**REVISED PLANNING APPLICATION FOR THE INSTALLATION OF AN AIR SOURCE HEAT PUMP AT CAMPUS WEST,
WELWYN GARDEN CITY**

On behalf of our client, Welwyn Hatfield Borough Council (the applicant), we write to submit this revised application for the installation of an air source heat pump at Campus West, Welwyn Garden City. The submission has been made via the Planning Portal and the reference number is PP-11121968.

As officers will be aware, permission was granted on the 17 December 2021 (LPA Ref: 6/2021/1788/FULL). This application seeks a slight change to the permitted development. This application seeks to slightly adjust the steel frame location and the 3m acoustic fencing (albeit retained within the same vicinity) to accommodate an existing cable tray and pipework.

Drw No. P4252-PESP-AZ-RF-DR-ME-58-9150

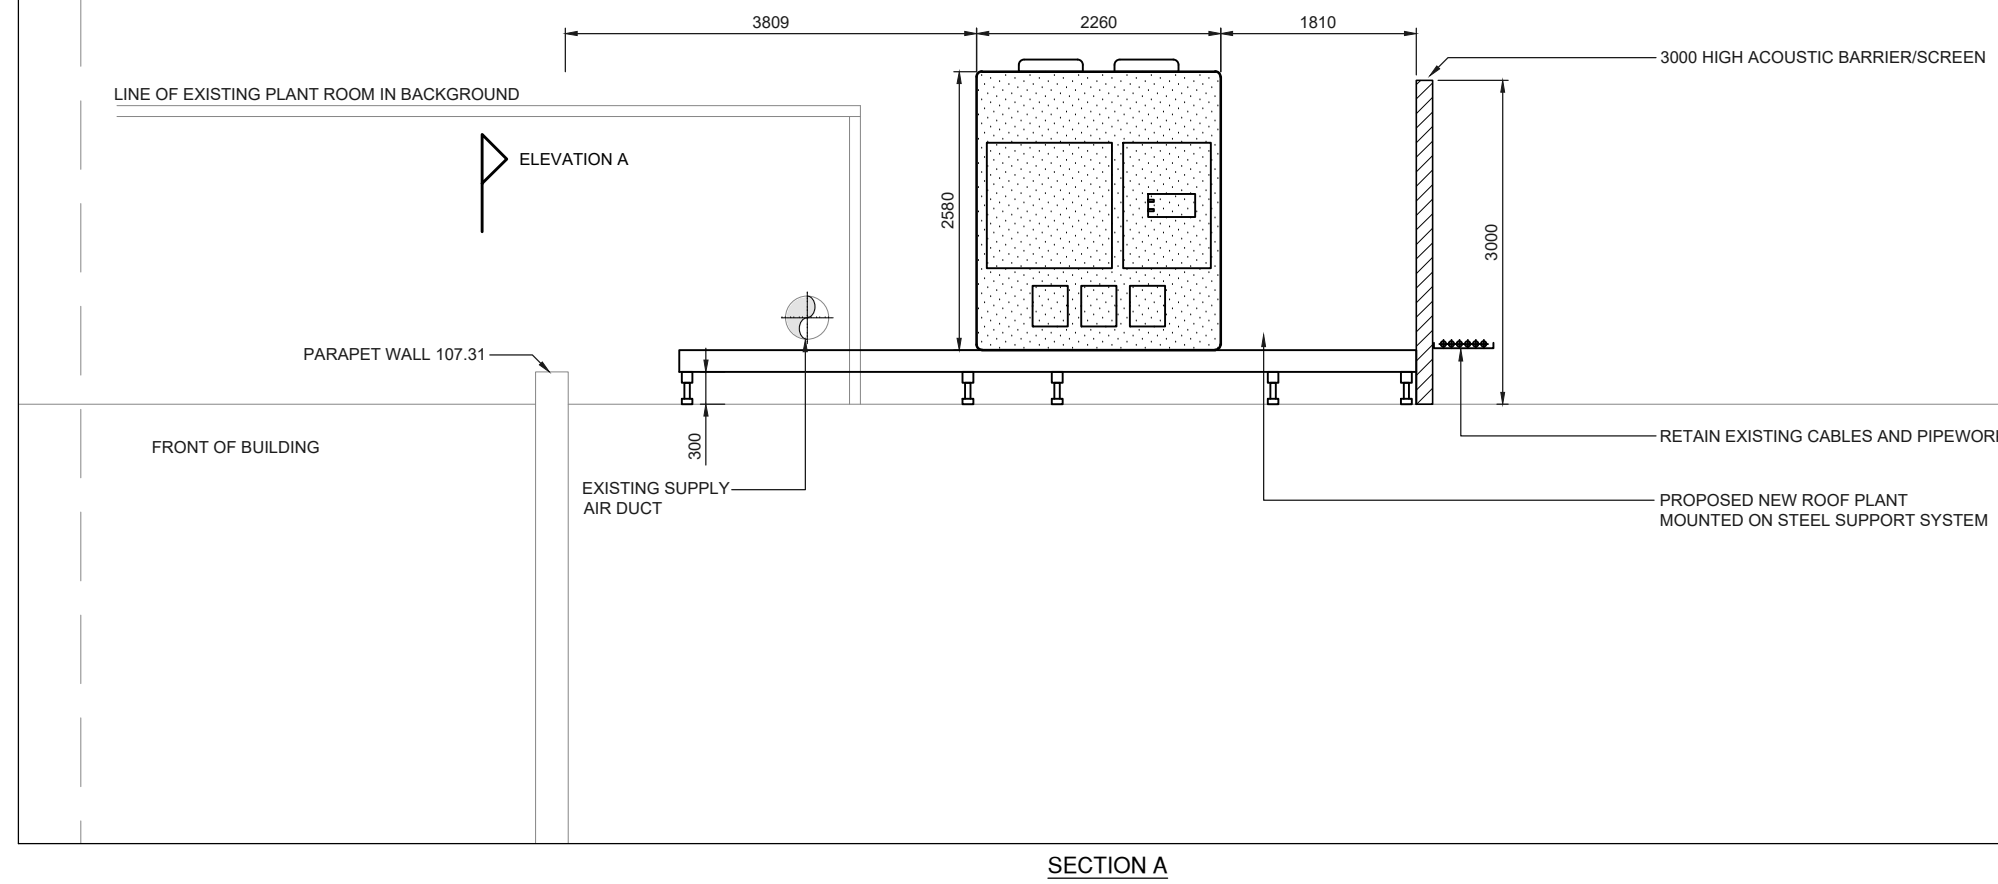
Campus West is one of the sites to be upgraded. Planning permission has previously been granted for the installation a roof mounted air source heat pumps to be installed at the site (LPA Ref: 6/2021/1788/FULL), however this application seeks to slightly reposition the unit and the acoustic barrier to accommodate existing plant equipment located on the roof.

This resubmission seeks only a minor amendment from the approved application (LPA Ref: 6/2021/1788/FULL). The slight change in location is required to accommodate the existing plant equipment and will not have any greater impact on the visual appearance or amenity than the permitted development.

| Plan Reference / Document | Approved | Amended |
|---|--|---|
| Proposed Plans and Elevations | P4252-PESP-AZ-RF-DR-ME-58-9150 Rev 3, dated 17 September 2021 | P4252-PESP-AZ-RF-DR-ME-58-9150 Rev 5, dated 21.02.2022 |
